Subject: SSI-8862

Beaches Link and Gore Hill Freeway Connection EIS:

This submission is an objection to Beaches Link Tunnel Project.

**Figure 3-4 Forecast change in weekday traffic volumes average (two-way) in the AM peak on key Northern Beaches corridors by 2037**

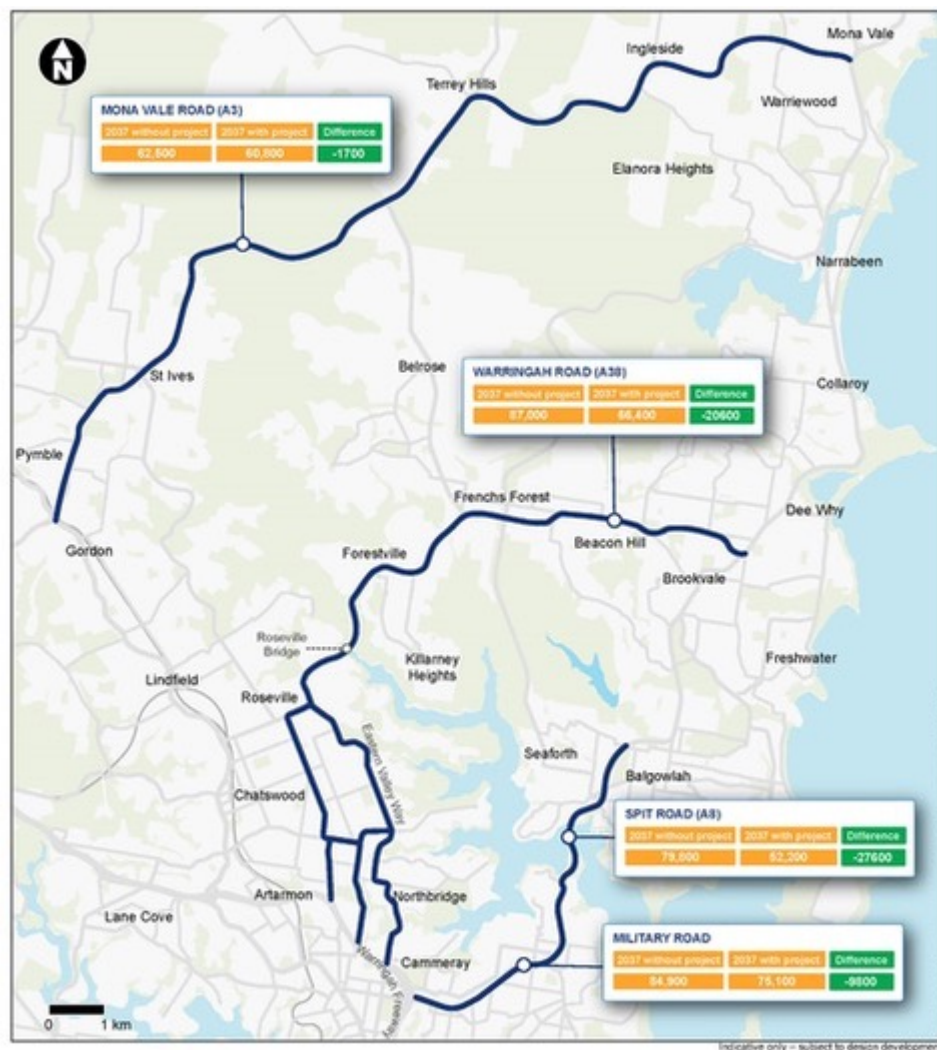
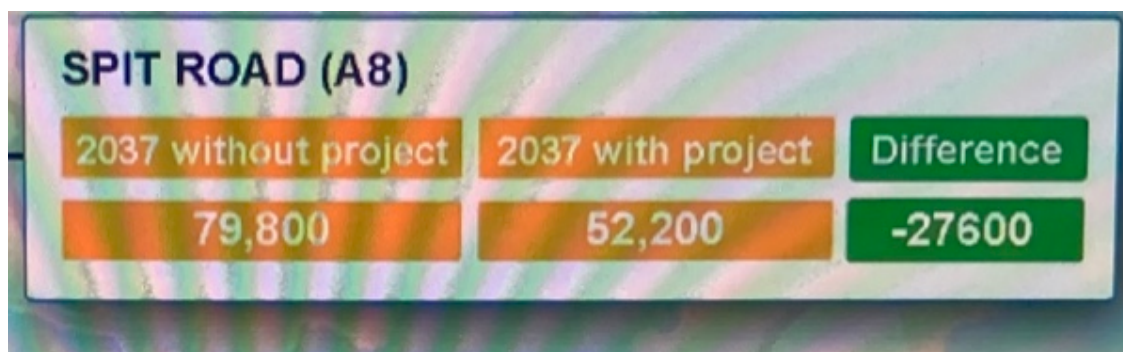
If one looks at Figure 3-4 (Appendix Altman) one can see that the term 'AM peak' is an error. (See amendment in Appendix (Altman)).

If we look at Pages: 3-8, 3-9 and 3-10 from Chapter 3 of the EIS, with the statistics in Figure 3-4 of the EIS (Appendix (Altman)) issues are highlighted at present and future:

'Figure 4-4 Average weekday **trips** via key transport corridors (existing conditions)'

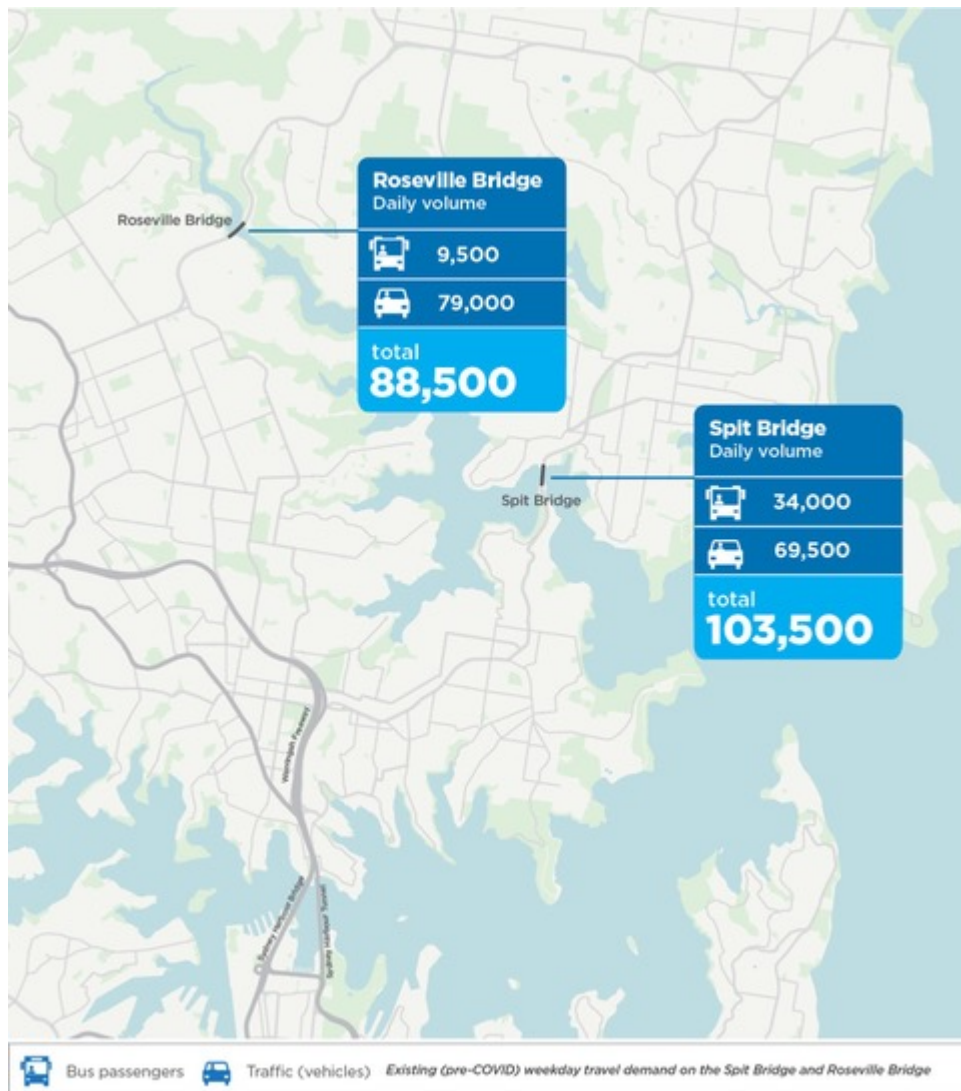
Figure 3-2, Key metrics for the critical Middle Harbour road crossings and Figure 4-4, show average weekday trips via key transport corridors (existing conditions i.e. 2016 modelling).

Figure 4-4 shows a conservative passenger total which journey every day.

Looking at figure 3-2 and 4-4, the daily figure given of 69,500 vehicles over the spit bridge and 79,000 over the Roseville Bridge corridor totals 148,500 journeys per day.
